From: Cruse & Associates <cruseandassoc@kvalley.com>
Sent: Monday, January 08, 2018 1:25 PM
To: Chelsea Benner; Justin Turnbull
Subject: Re: Woody BLA BL-17-00018
Attachments: Woody Property.pdf

Justin and Chelsea – Attached is an preliminary map of the Woody BLA survey updated to address PW comments. The area for Sisters Road right of way is included in both the title report and tax records for the Woody property. The owner would like to clean up the right of way but concerned he keep losing acreage. He does not want to alter the south

WOODY PROPERTY

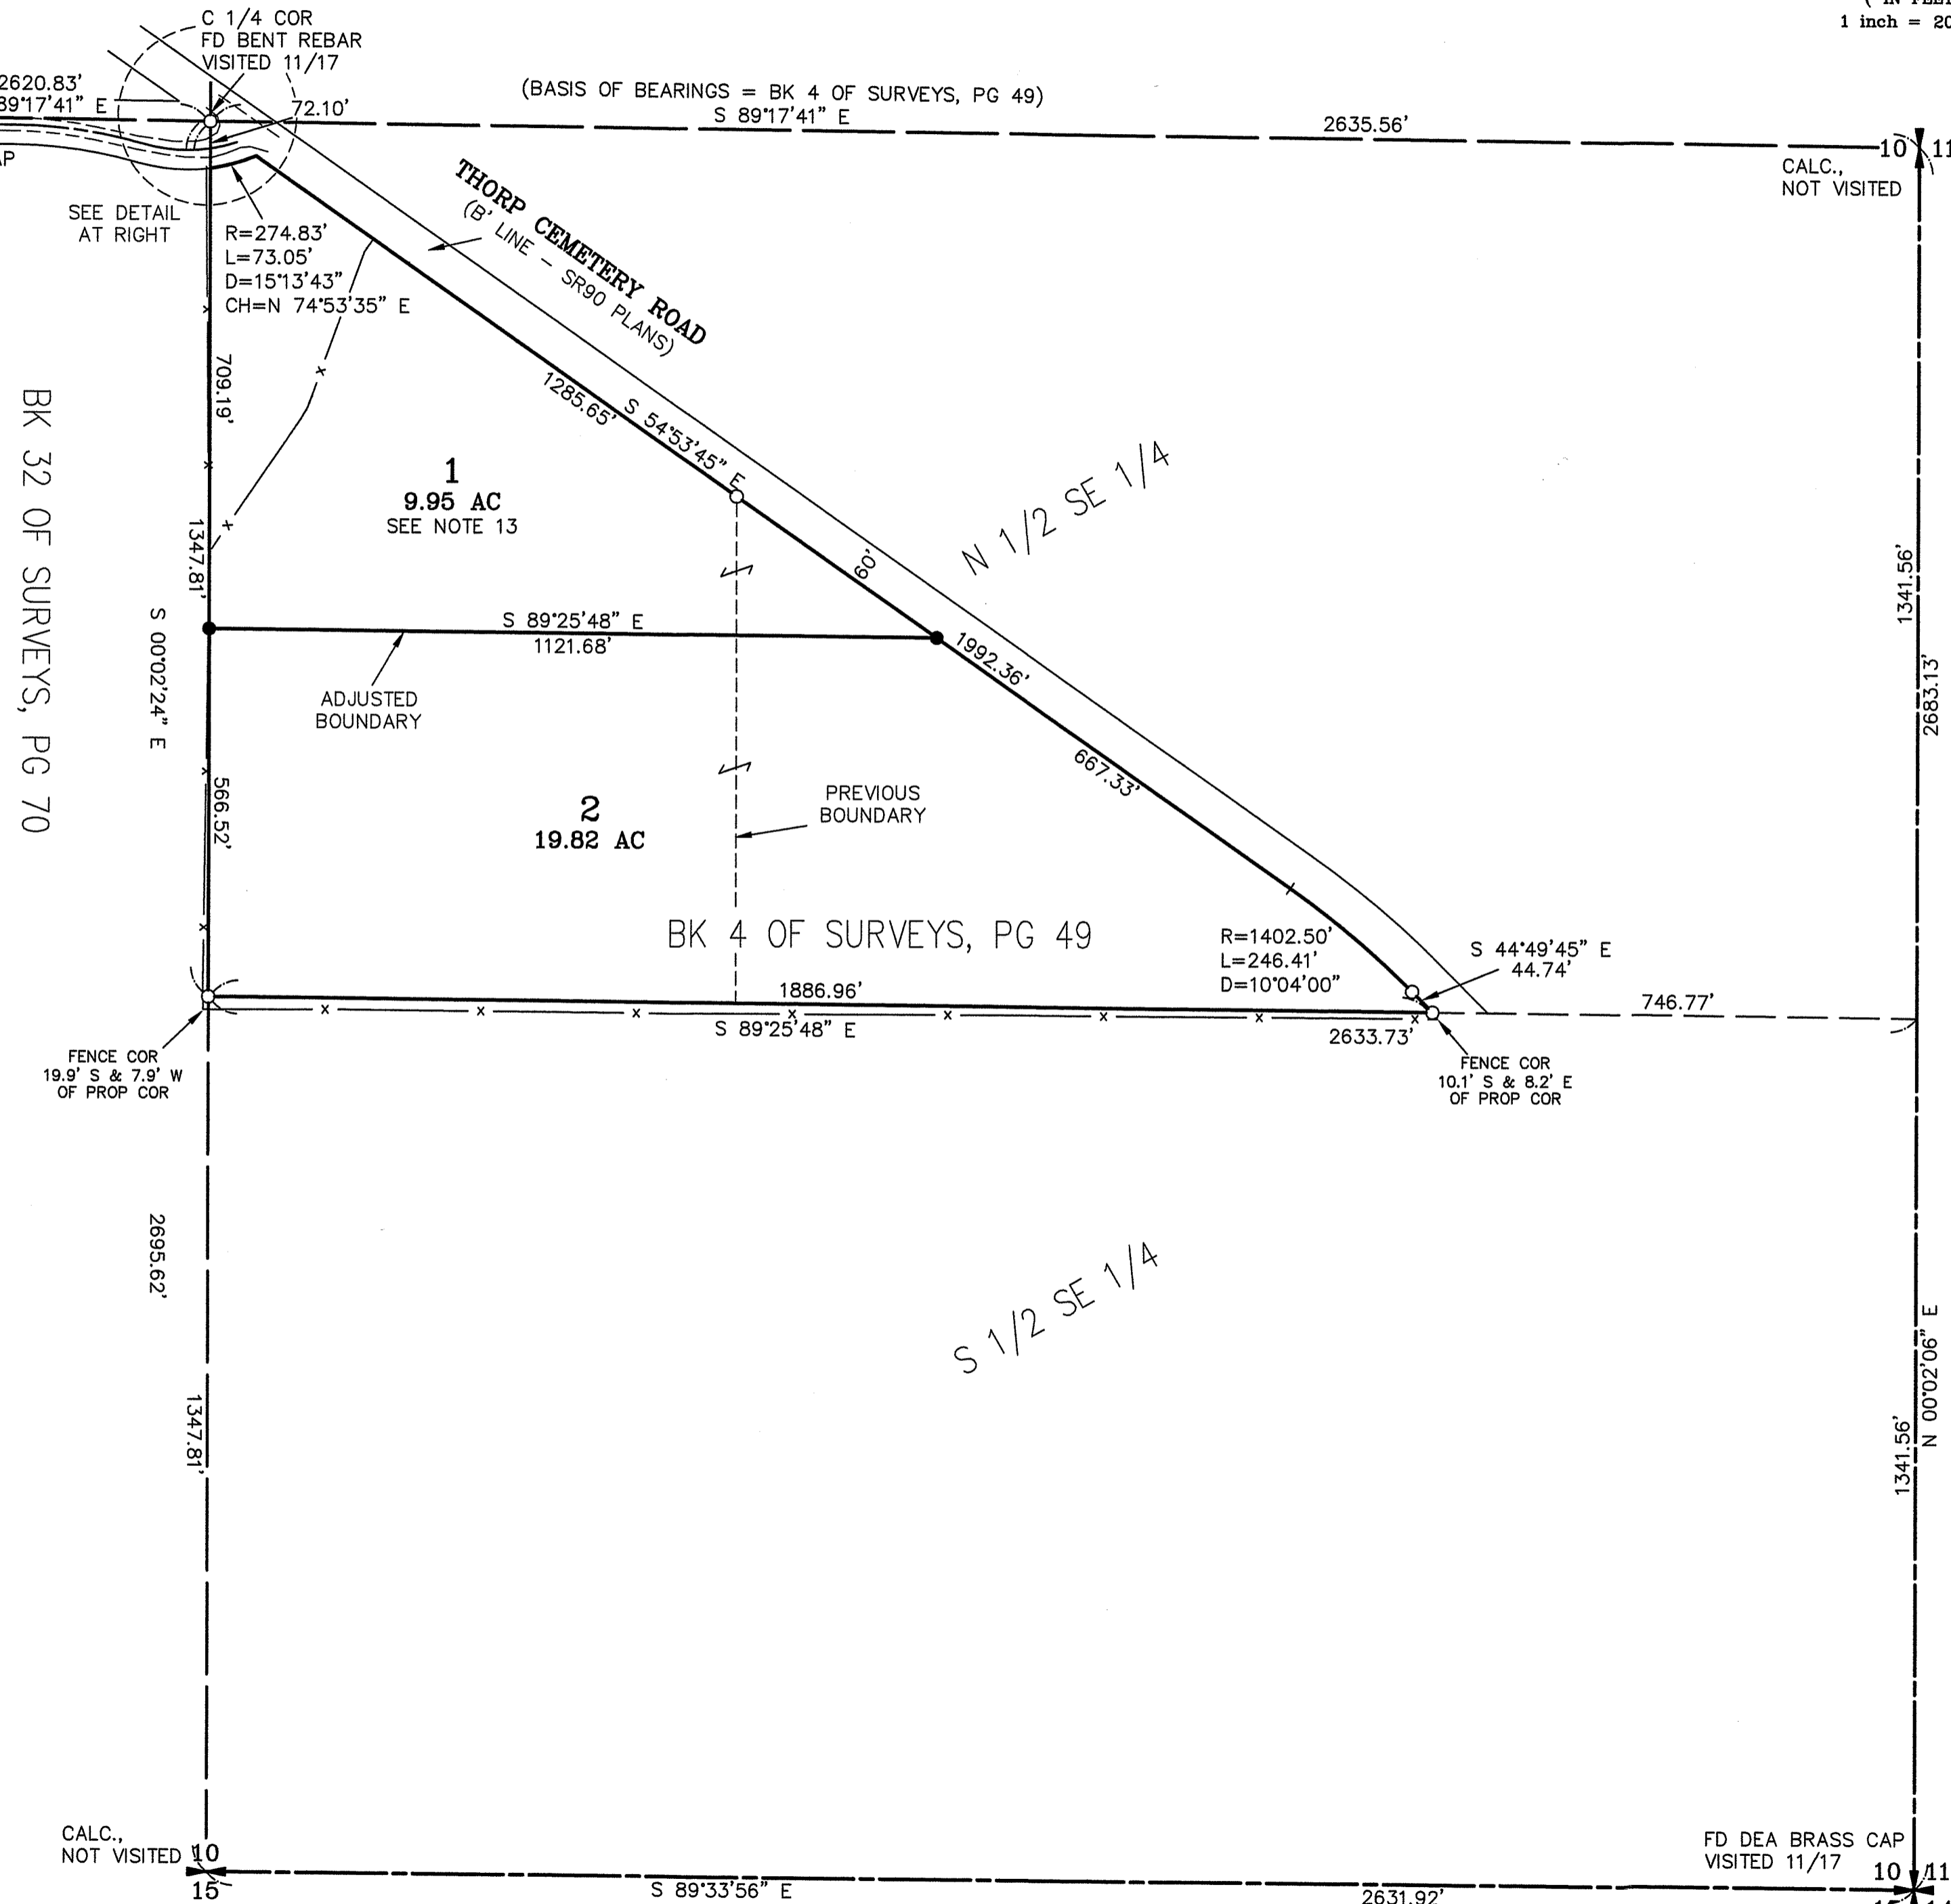
I talked this over with Lindsey and we determined that the .05 acres can come out but needs to come out of the larger parcel as that is where it originally was included.

WOODY PROPERTY

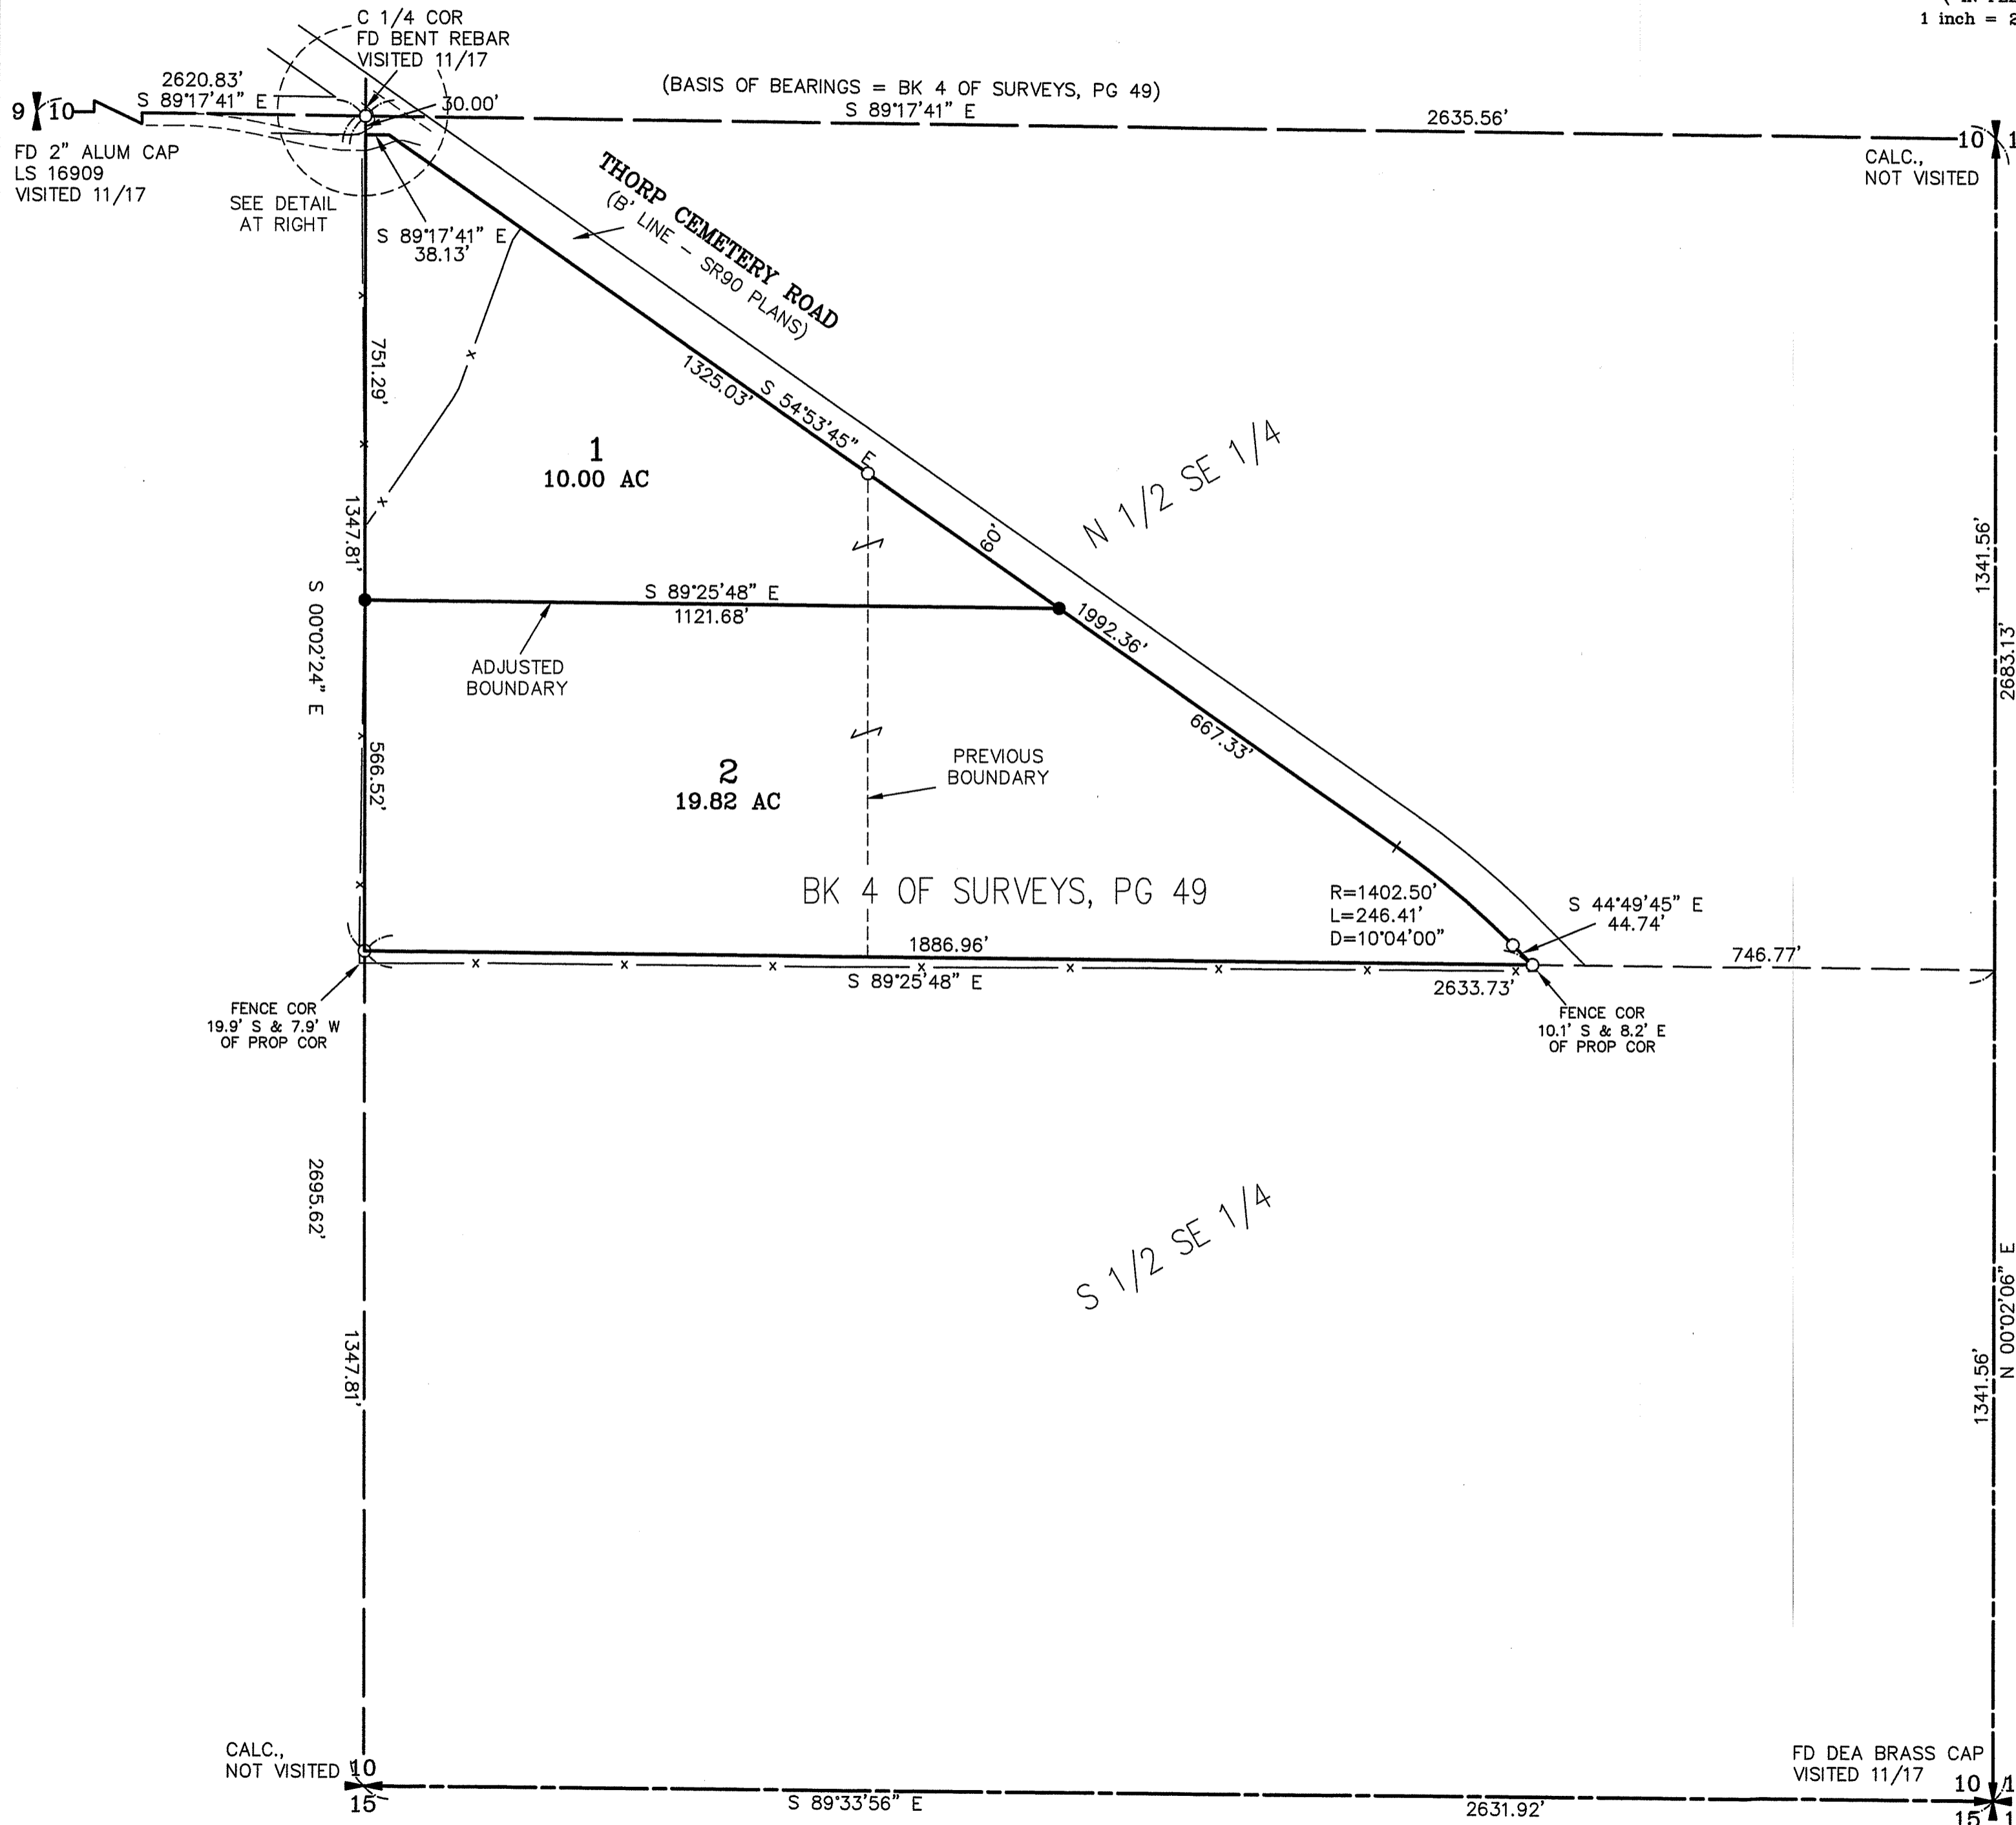
Chris,
Our records fail to mathematically describe the roadway in any form. We have visual representation of the roadway for utility franchises from 2015, 2008 and 1974 all showing the road bending, and Aerial photography from 1954 show the bend in the road as occurring prior to the construction of I-90.

Sunquist performed an adjacent survey in 2007 and shows the roadway clearly bending and holds the roadway as not being centered about the section line..

From my records, the lack of documents creating the roadway (deeds or road grants), combined with the long history of the road bending, leads me to lean towards centering the Right of way about the existing roadway, and holding a 60' R/W by prescription per RCW:36.75.070.

It appears that the only survey in disagreement with this is Skinners survey from 1977.

boundary of Parcel 1 that has been established. I am hoping CDS will approve this layout of 9.95 acres recognizing it is 10 acres as originally described but losing 0.05 acres to clean up the Sister Road Right of Way conflict. I added note 13 to clarify this issue.

If Parcel 1 needs to be 10 acres I will add the right of way back into the parcel and address the Sisters Road right of way conflict with a note. Please review and contact me back with any questions/concerns or notice to proceed and we will record.
